City of Portland, Maine – Building or Use Permit Application 389 Congress Street, 04101, Tel: (207) 874-8703, FAX: 874-8716

Location of Construction: * 30 Dayton Street, 04103		Owner: Charles & Janice Shannon *		Phone: 797-6058		Permit No: 000488	
Owner Address: 30 Dayton Street, 04103		Lessee/Buyer's Name:		Phone:			Permit Issued:
Contractor Name: Scott Proctor		Address:		Phone:		Zone: R-3 CBL: 339-C-015 Zoning Approval: OK - 5/16/00 Special Zone or Reviews: <input type="checkbox"/> Shoreland N/A <input type="checkbox"/> Wetland <input type="checkbox"/> Flood Zone <input type="checkbox"/> Subdivision <input type="checkbox"/> Site Plan maj <input type="checkbox"/> minor <input type="checkbox"/> mm <input type="checkbox"/>	
Past Use: Single family dwelling		Proposed Use: SAME		COST OF WORK: \$ 3,000.00			PERMIT FEE: \$ 42.00
Proposed Project Description: Building 31' x 23 1/2' deck- wrapped around rear side of house.		Signature:		FIRE DEPT. <input type="checkbox"/> Approved <input type="checkbox"/> Denied		INSPECTION: Use Group R-3 Type 5B BOCA 99 Signature: <i>[Signature]</i>

BUILDING PERMIT REPORT

REASON FOR PERMIT: 6 1/2' x 21' deck 5' x 31' deck

Plot Plan

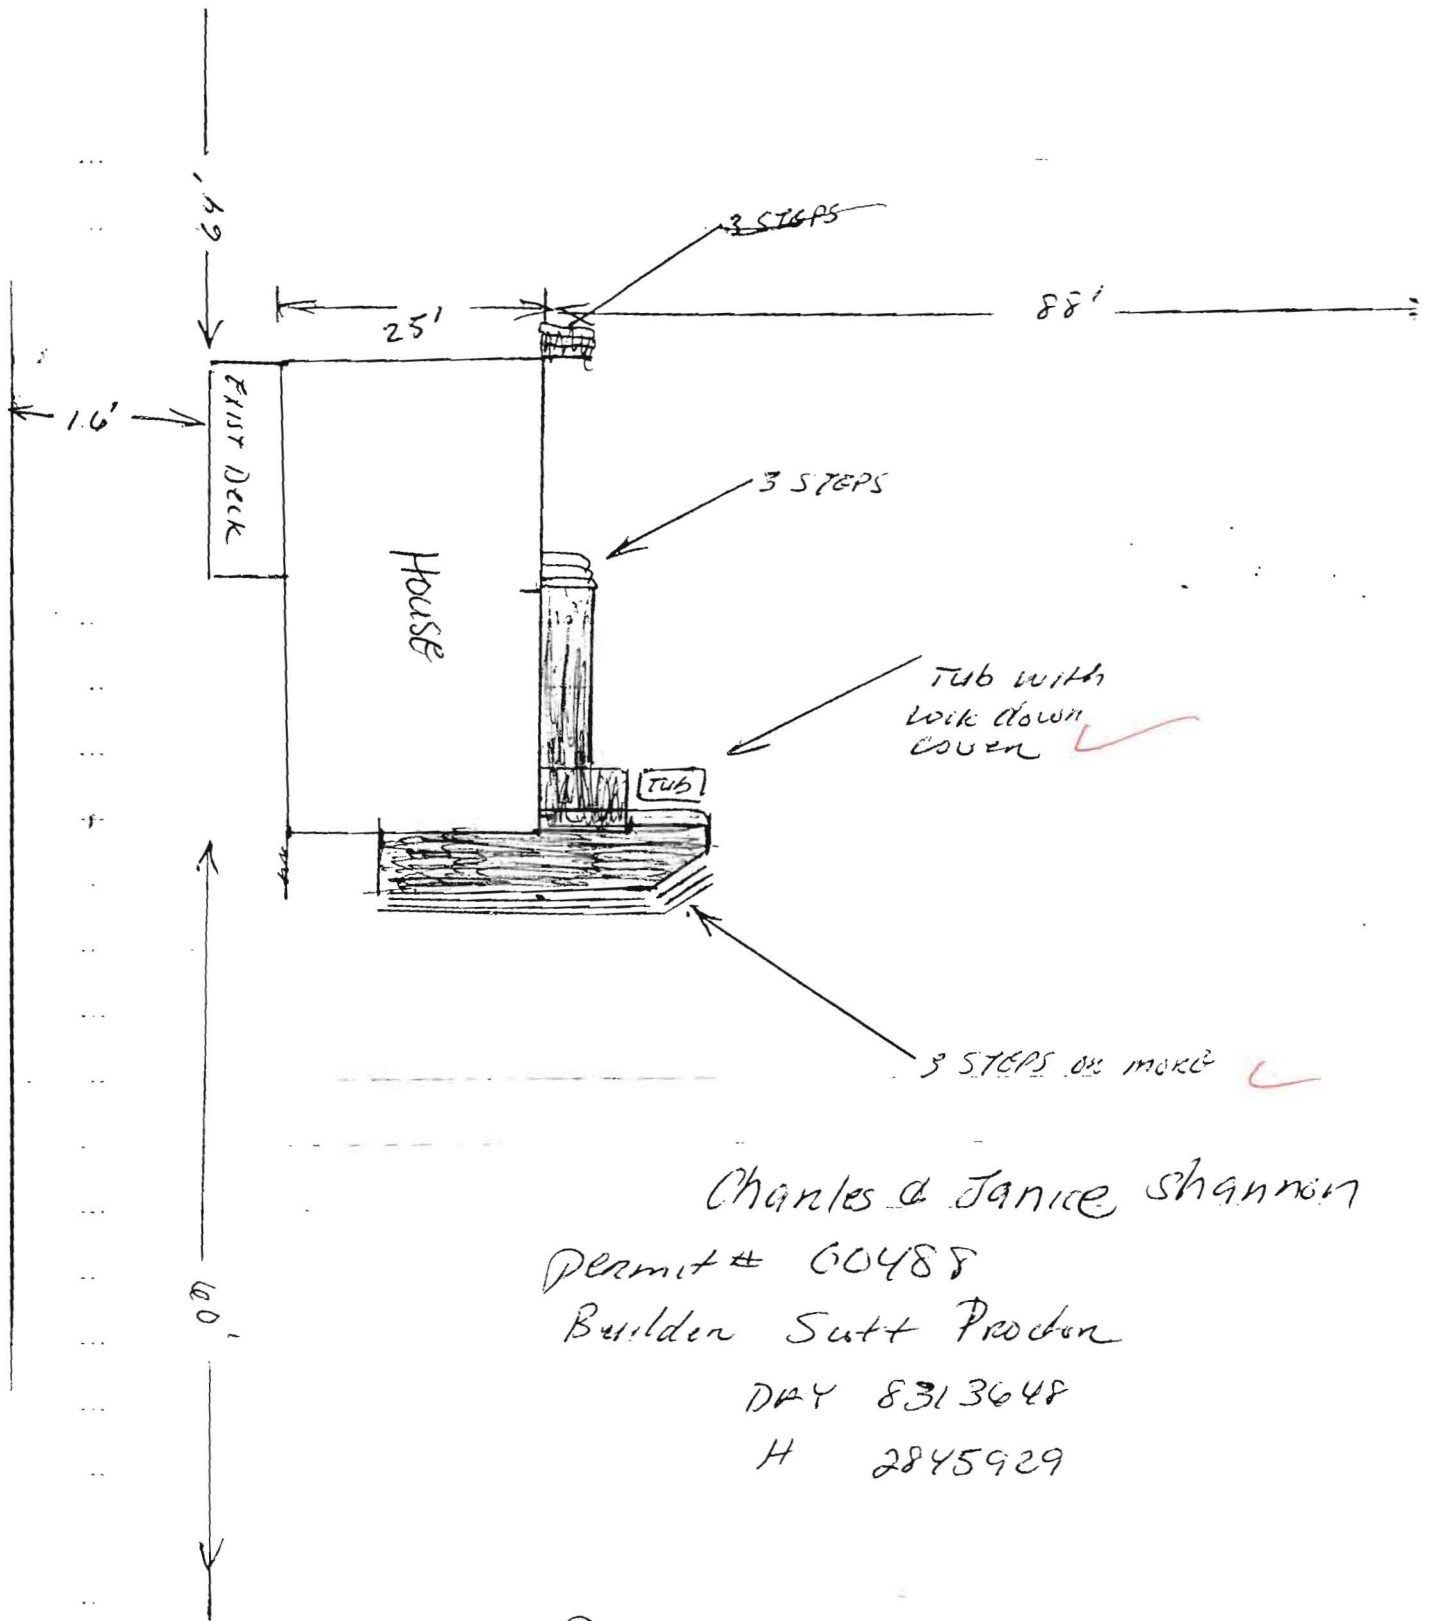
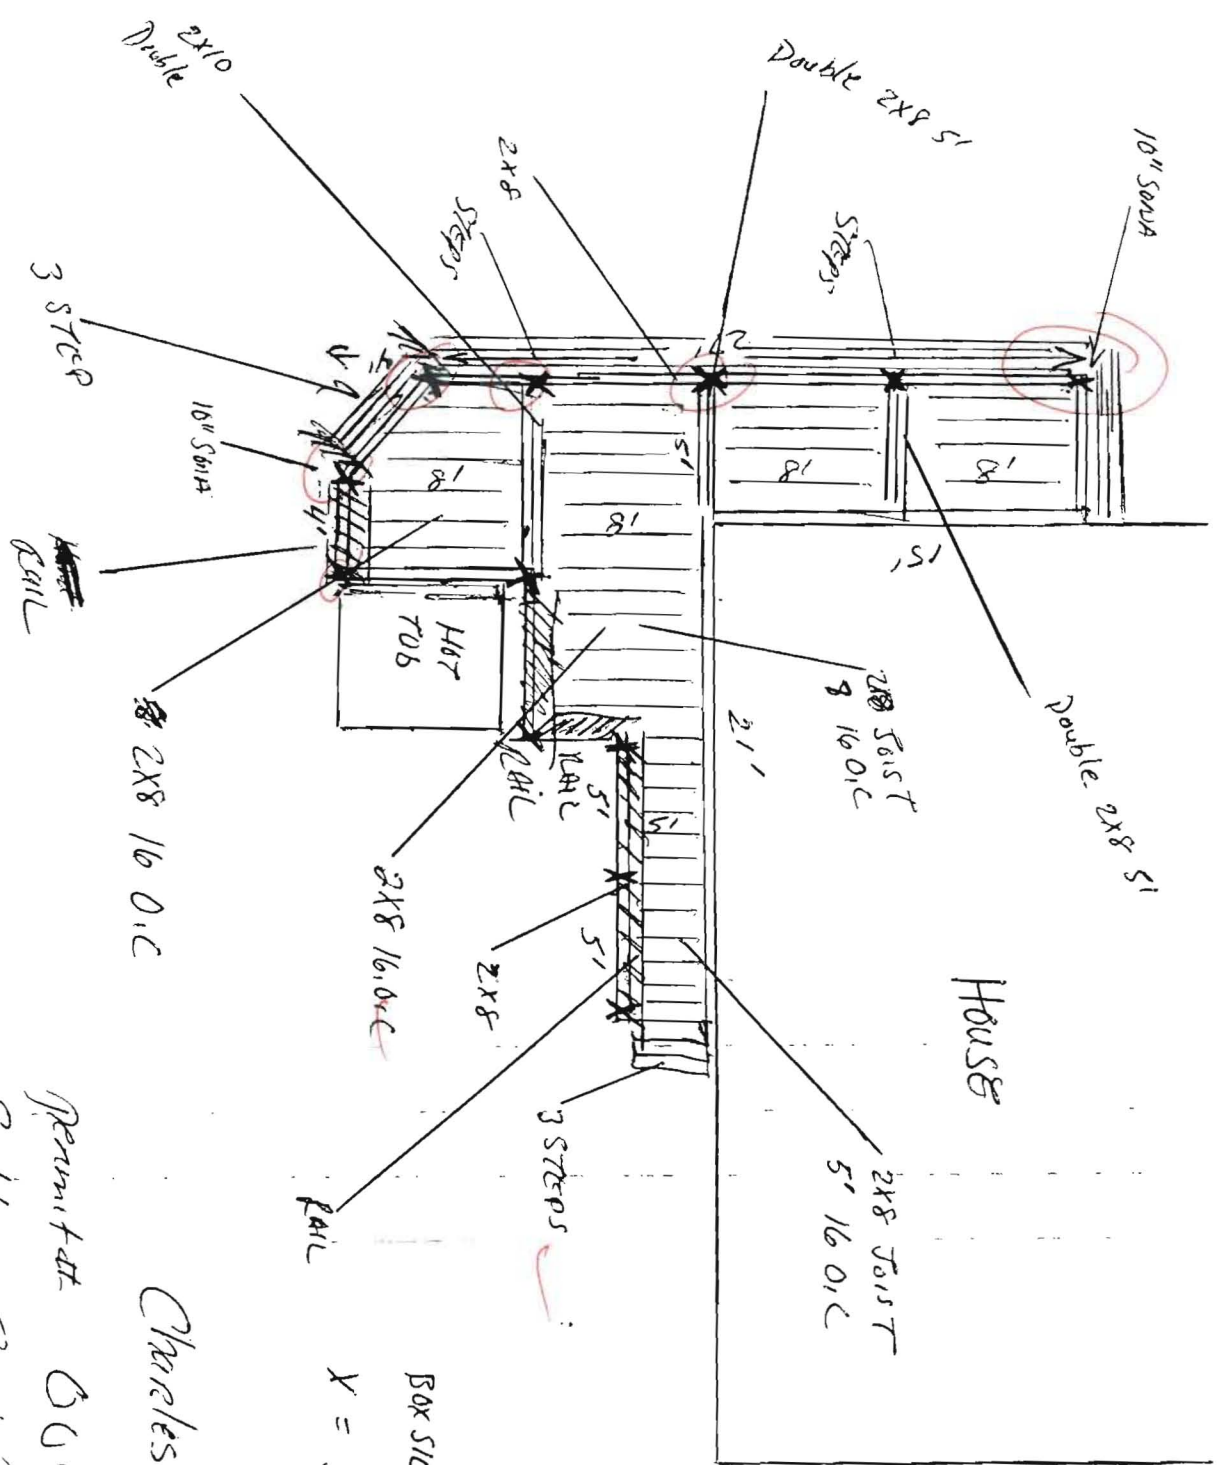
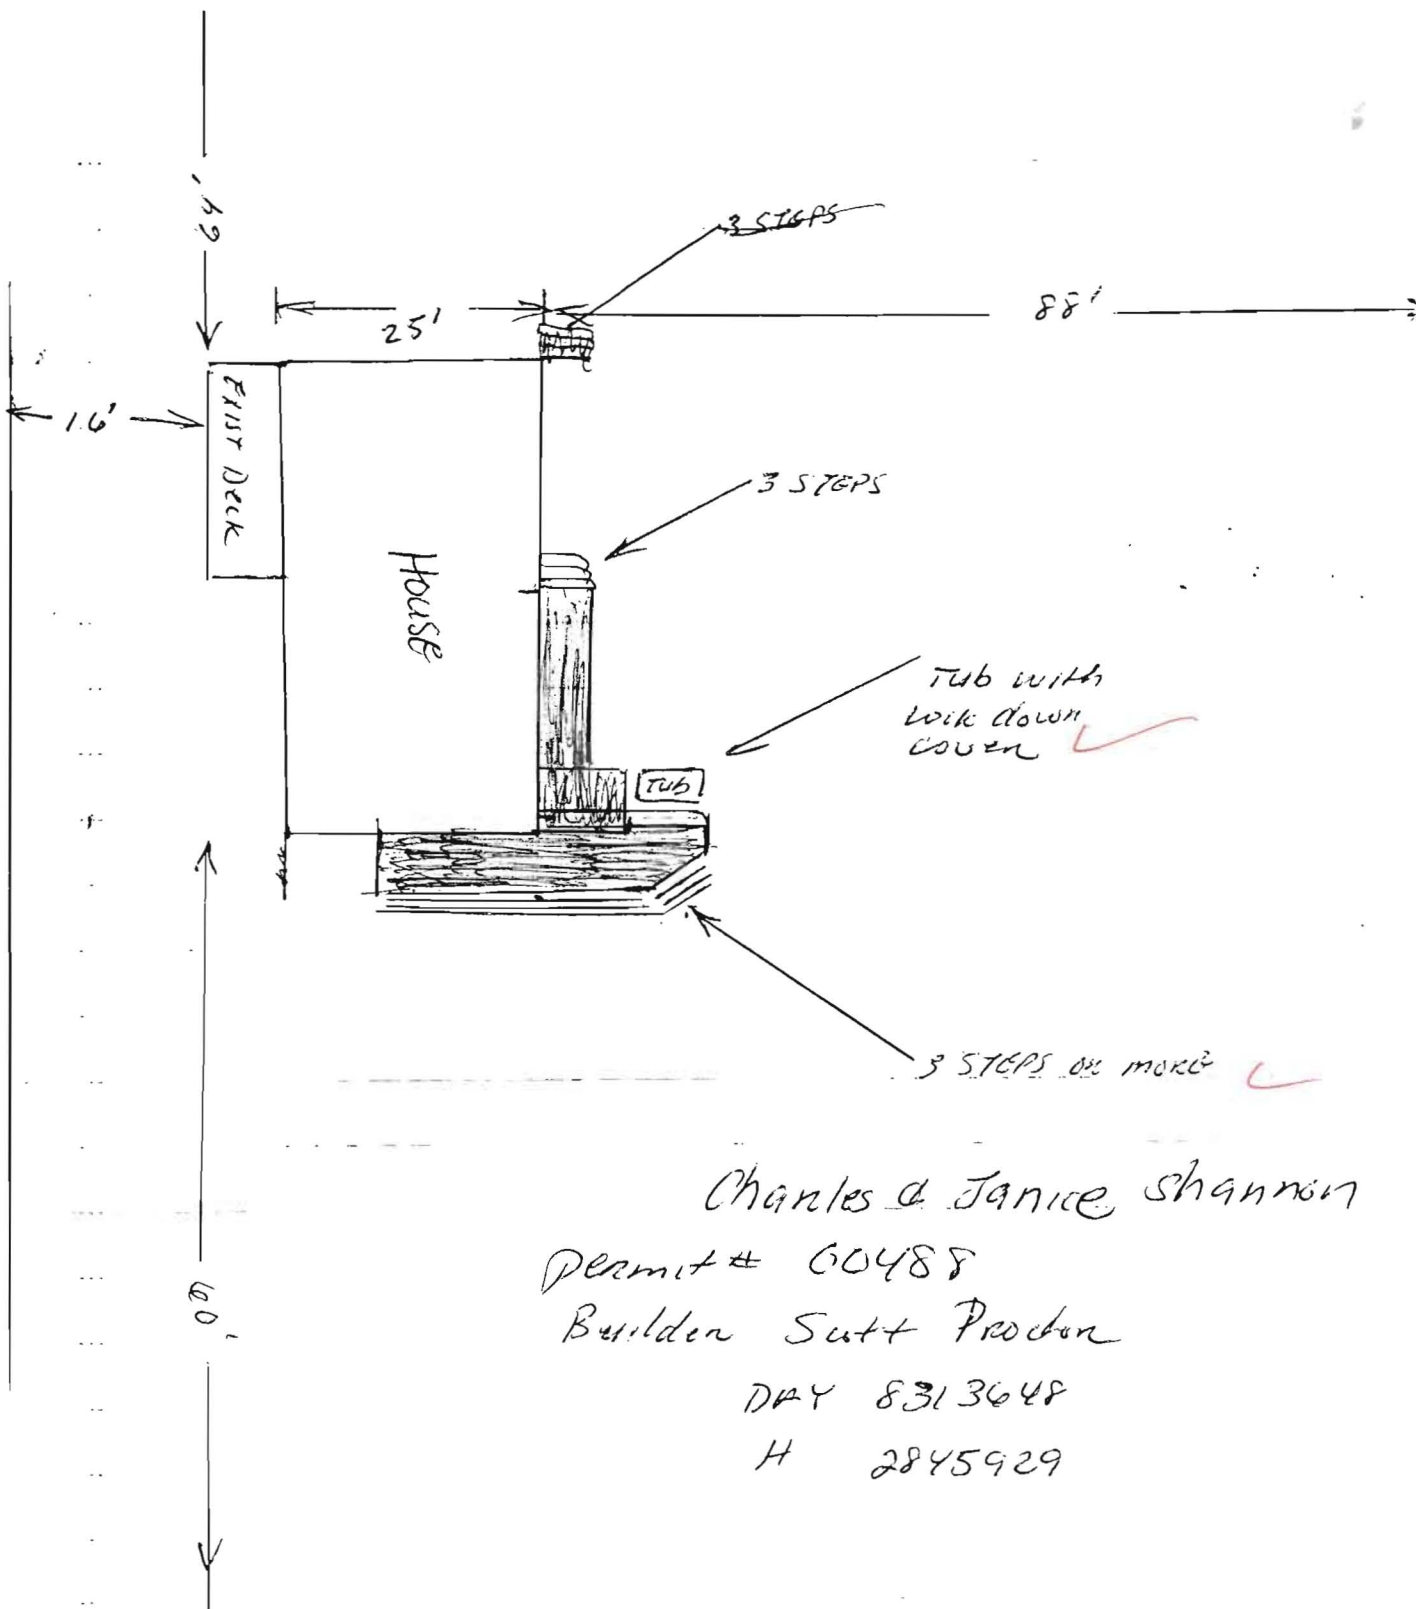
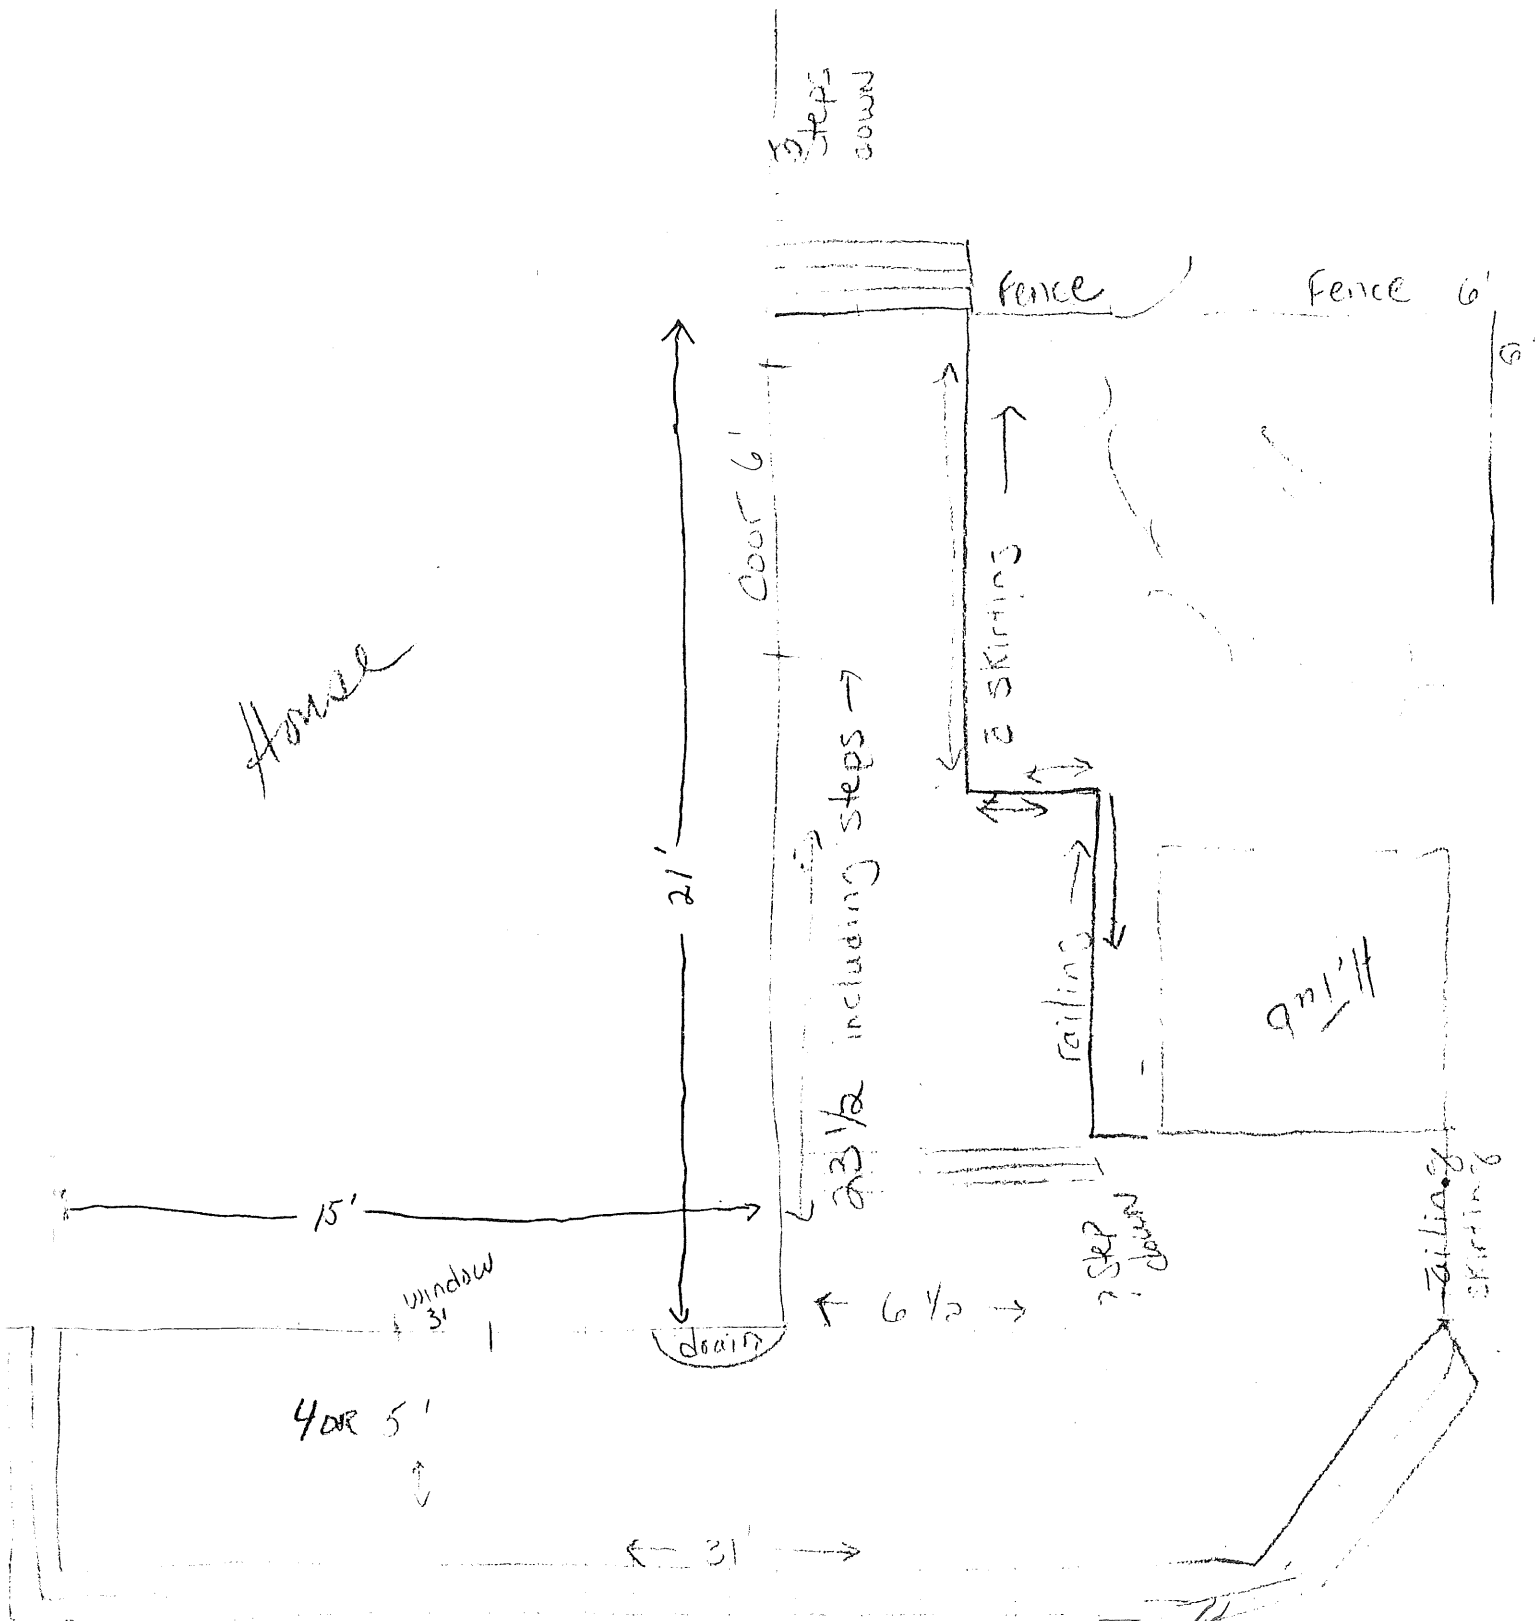
5/9/00
Deck not shown on plot plan

X 36. This permit is being issued with the understanding that before any work is started that a Framing detail be submitted to me for approval - your plans did NOT show the Foundation or Framing.

Received updated
 drawing 5/16/00
